From: [Natacha Osler](#)
To: [Philip Price](#)
Cc: [PScan1](#)
Subject: Re: Planning Application 20/02047/F
Date: 19 January 2021 07:49:36

Our ref: 21/00249

RE: Replacement of deteriorating timber framed asbestos garage/workshop with timber cabin/studio on existing concrete foundation.

B. Pre-existing asbestos/concrete building block plan at Cuckstool Cottage

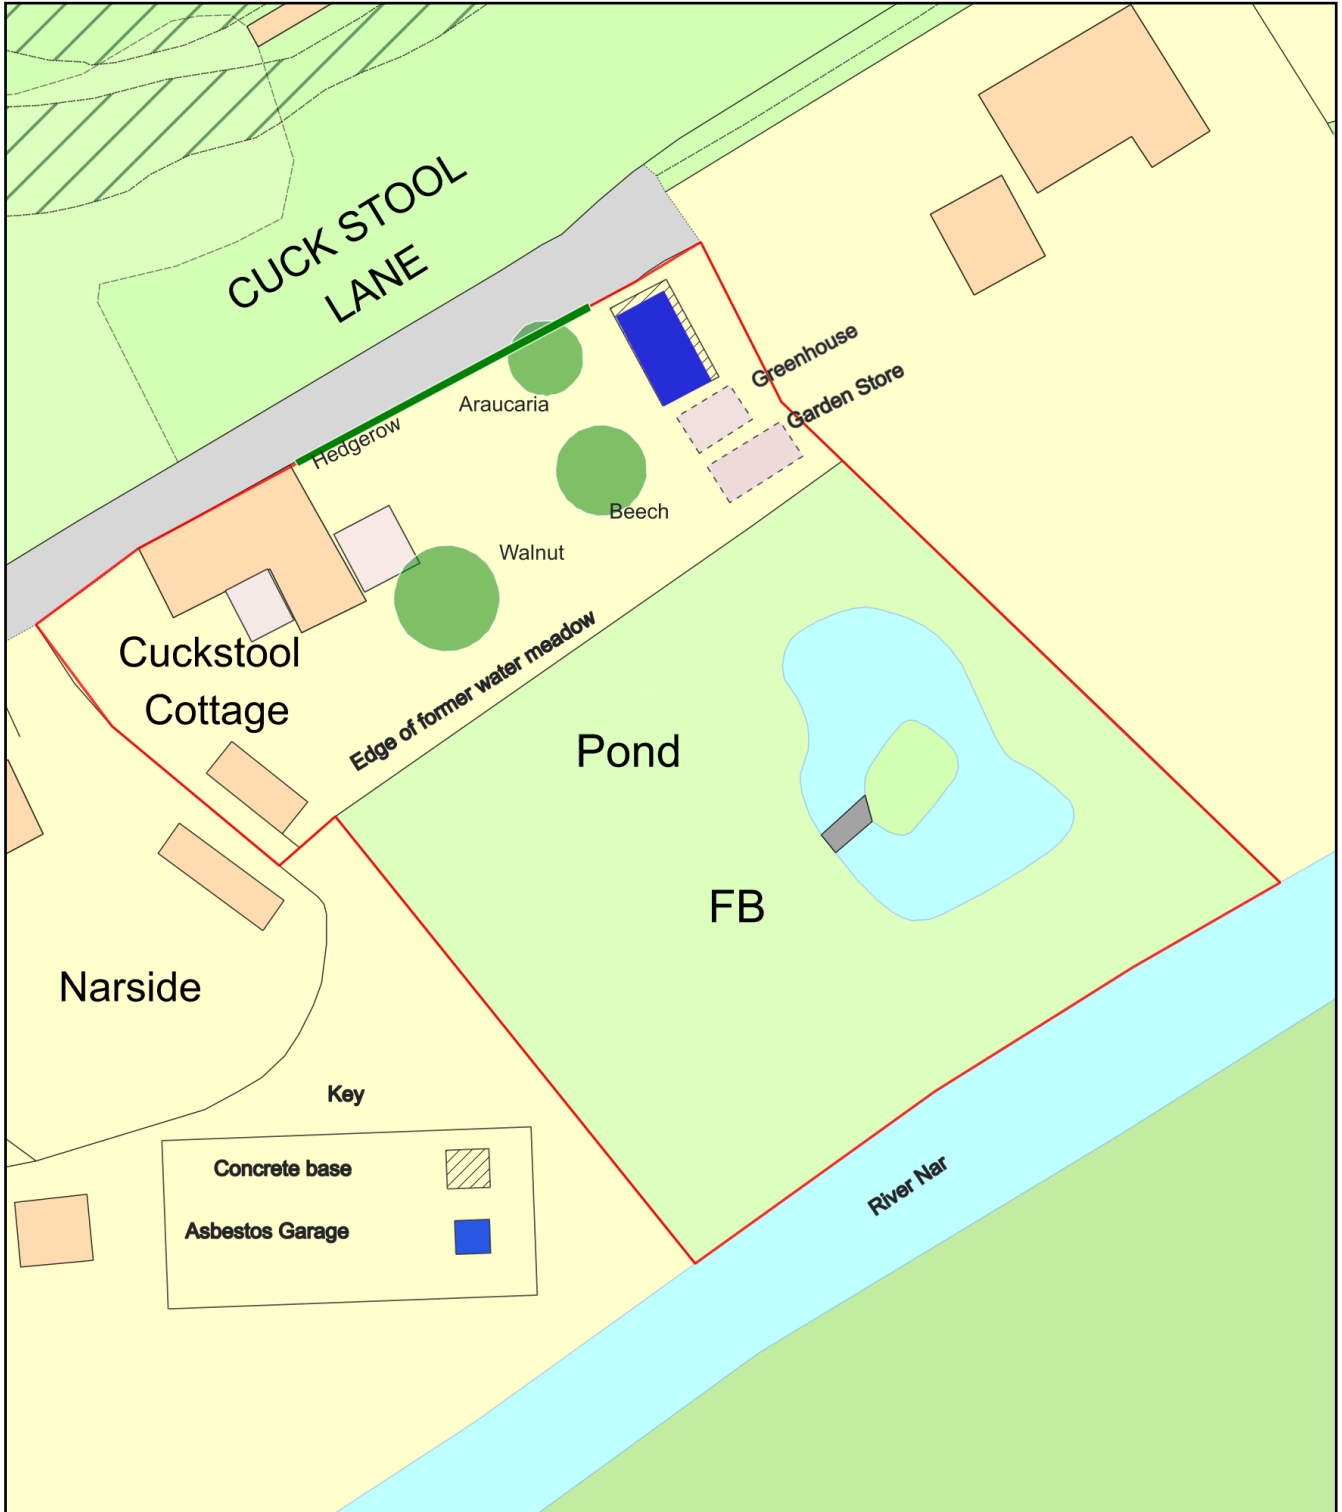
The site is identified as being occupied by a shed suspected of having asbestos containing materials in its fabric. In addition our files indicate potential ground gas sources in the vicinity of the site. The mapping also identifies a lime pit and lime kiln close to the site giving rise to potential contamination.

Given these potential sources of contamination, we recommend the following conditions:

- 10009 – site characterisation
- 10010 – submission of remediation scheme
- 10011 – implementation of approved remediation scheme
- 10012 – reporting of unexpected contamination
